Response to Planning Application

Application ref: Y/10/22/PL

Description: Erection of 15 No dwellings (including 4 No affordable units) with associated access, parking, landscaping, drainage and public open space (additional units to those approved under application Y/123/21/PL). This application may affect the setting of a listed building, affects the character & appearance of the Church Lane Conservation area, affects a Public Right of Way and is in CIL Zone 2 and is CIL Liable as new dwellings

Location: Land to the south of Ford Lane and east of North End Road Yapton BN18 0DS

Play Area (LAP 2) - Scale 1:100@A1

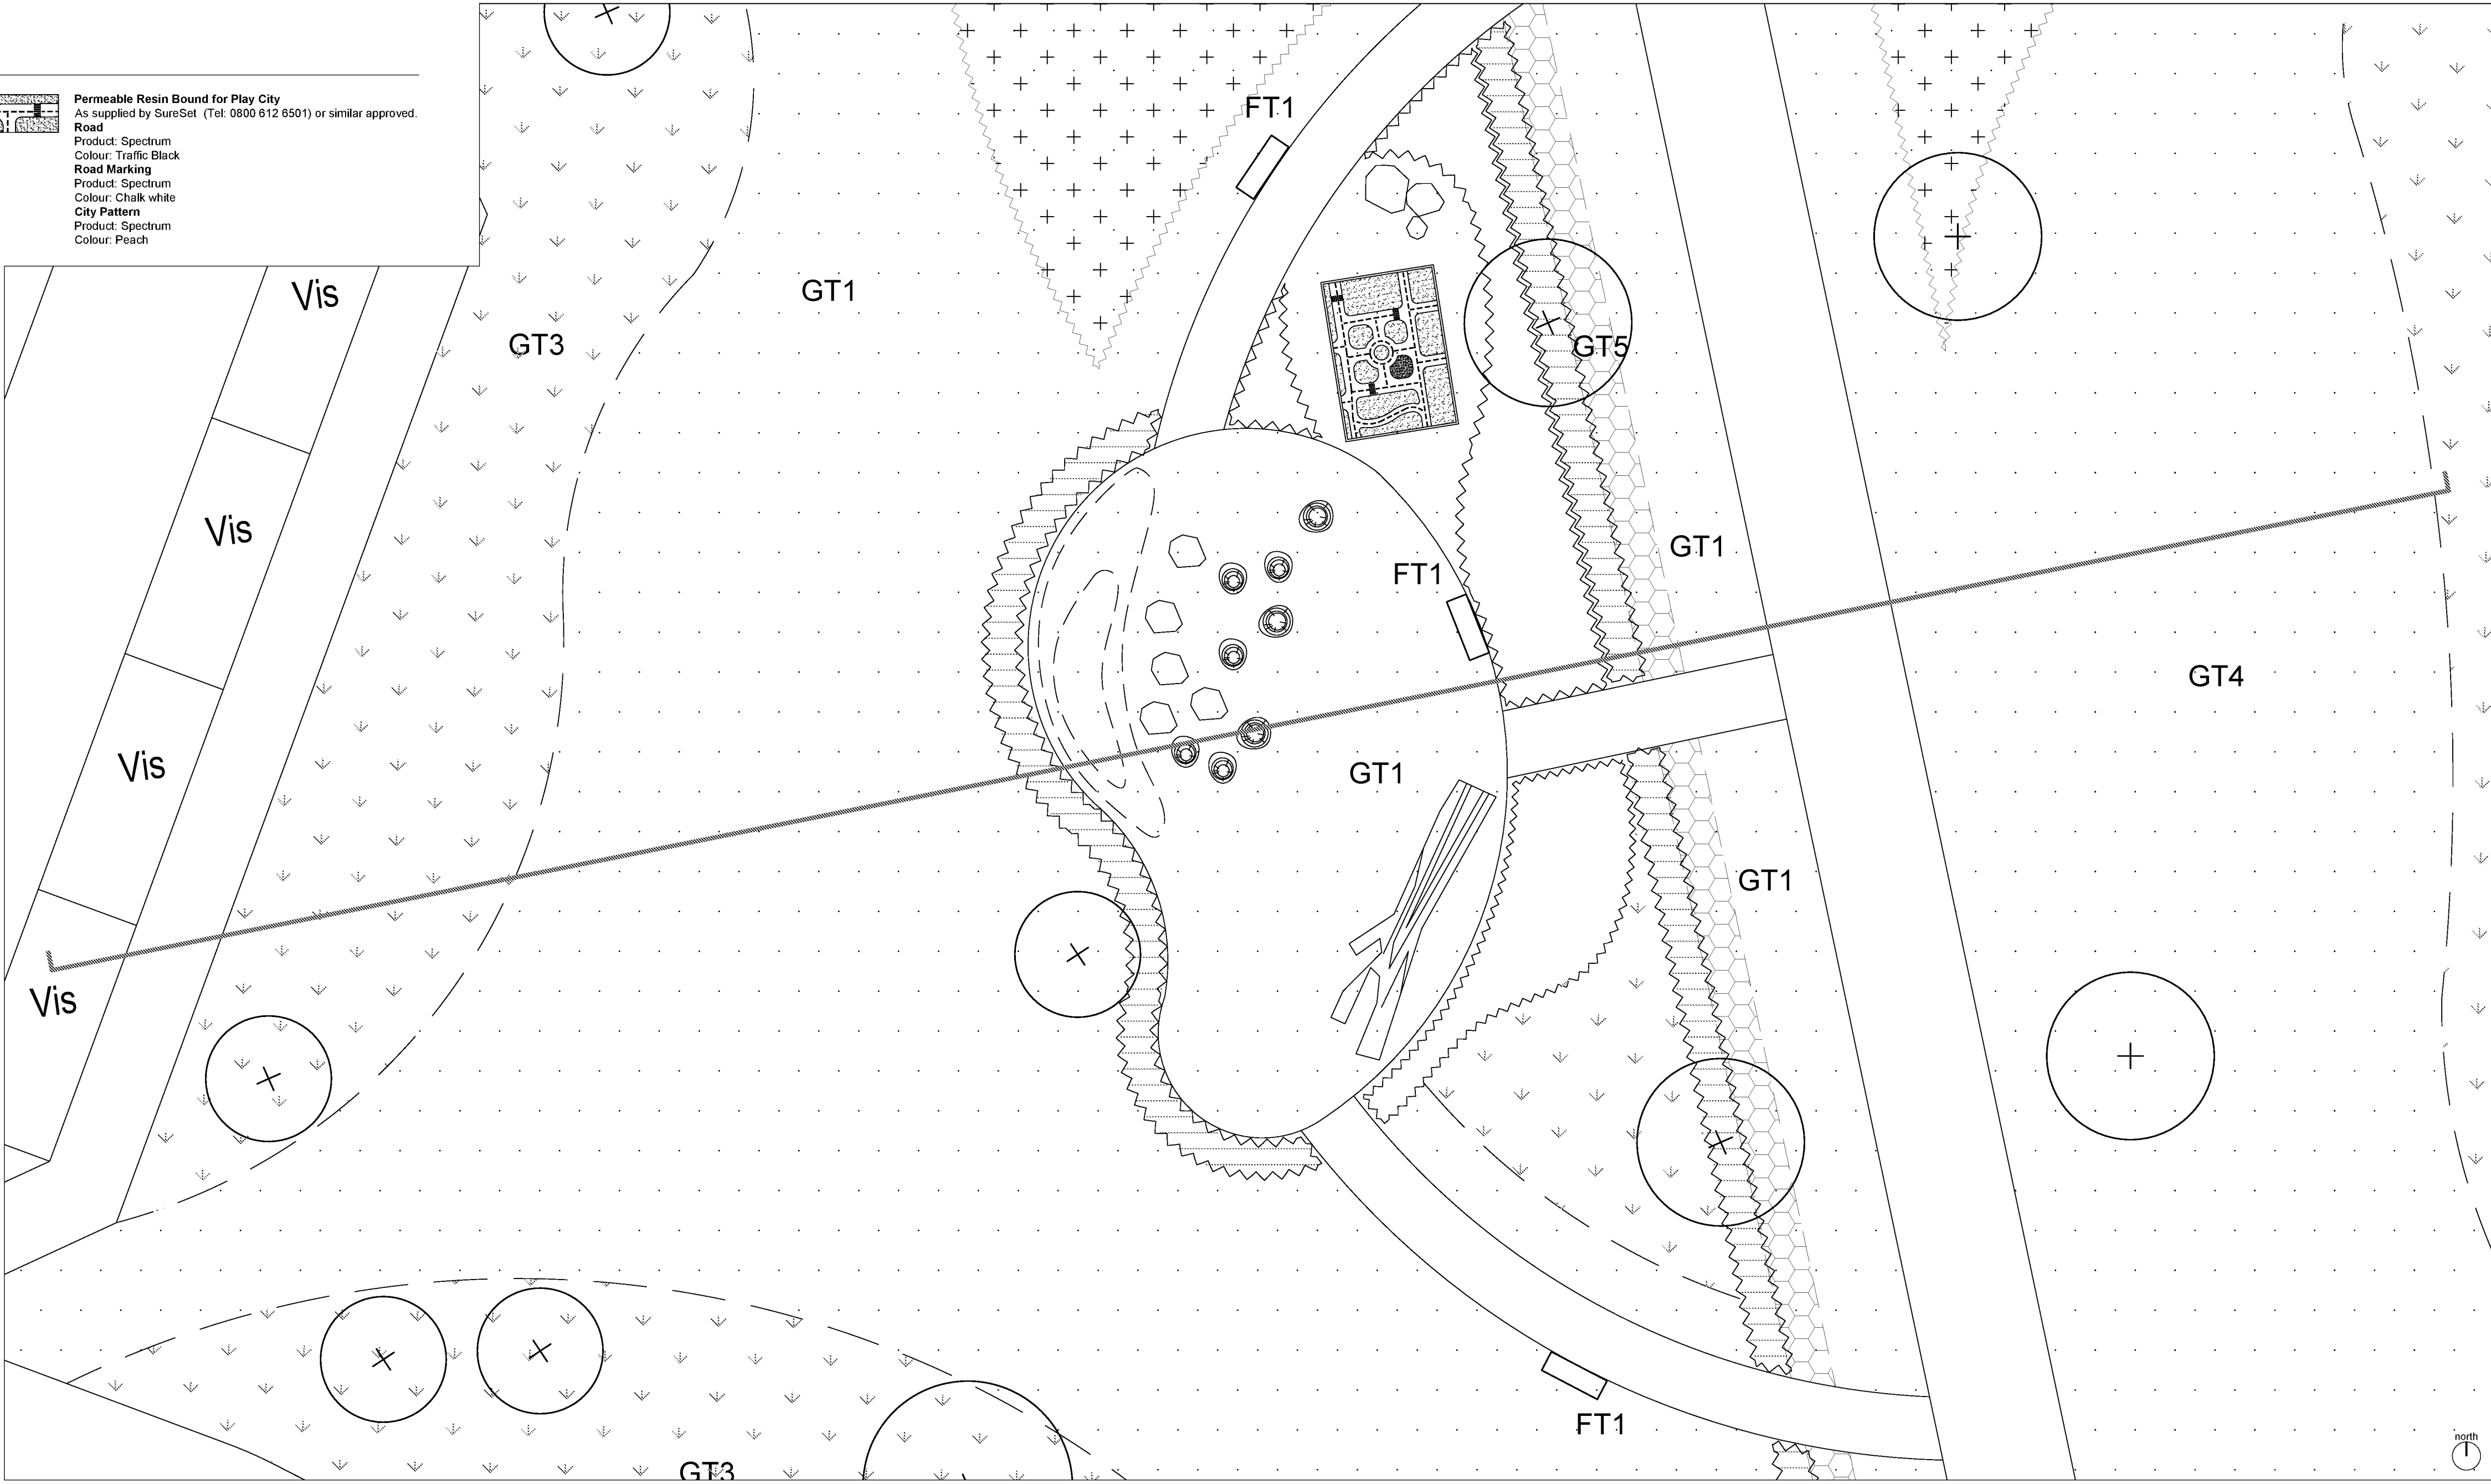
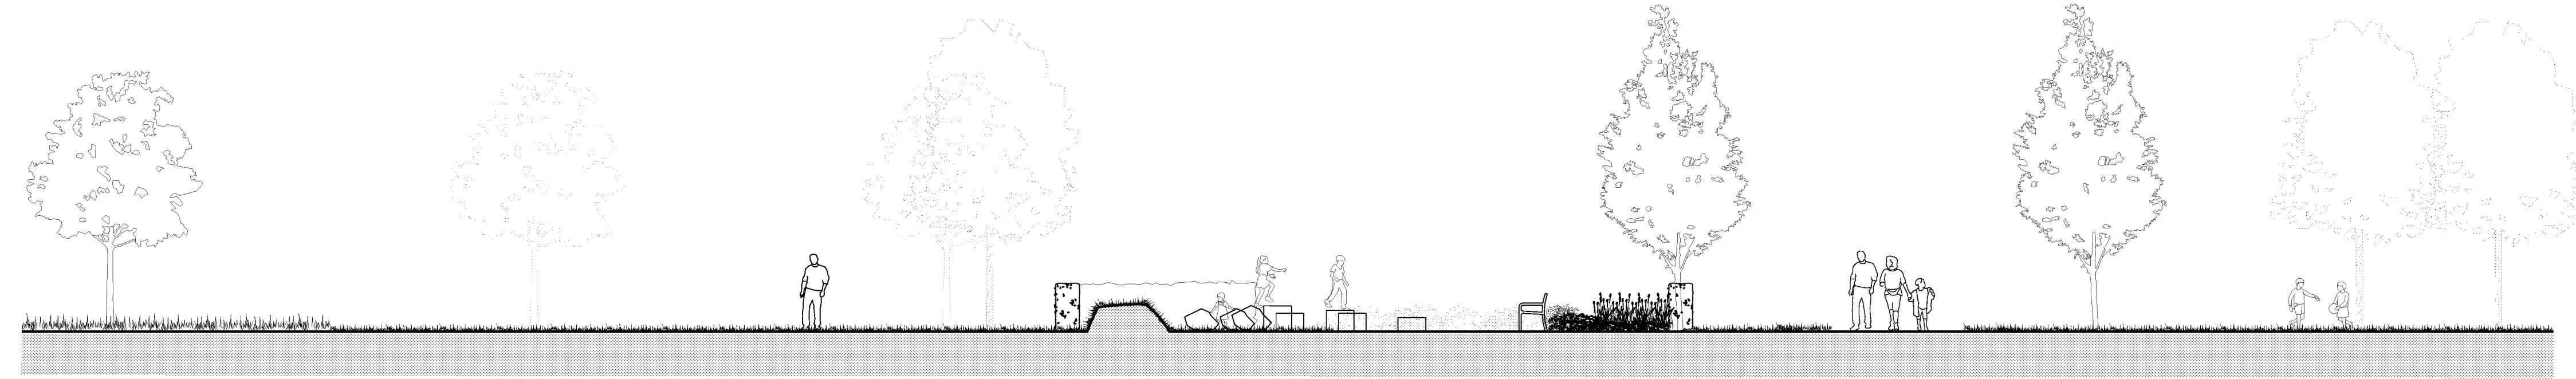
The POS areas including layout and setting were assessed under these previous applications including the agreement to site the LEAP to the west of the access road (where now shown for the additional 15no dwellings) The siting now of the LEAP to the east of the roadway puts it in direct conflict with the SuDS feature and the potential for conflict. Additional dwelling proposals should prompt the need for additional POS to be provided on site where the proposals very evidently will reduce the quantum and more over the quality and setting of the POS for the wider 100no unit development.

The potential impact of the proposal to site an additional 15no dwellings into the previously proposed POS area would be significant on the setting of the development and the subsequent re-siting of the LEAP into the vicinity of the SuDS area unsuitable.

I would not recommend any landscape mitigation to overcome the proposals in this application as **would strongly uphold an objection to the layout and encroachment of POS area, setting and LEAP re-location proposal.**
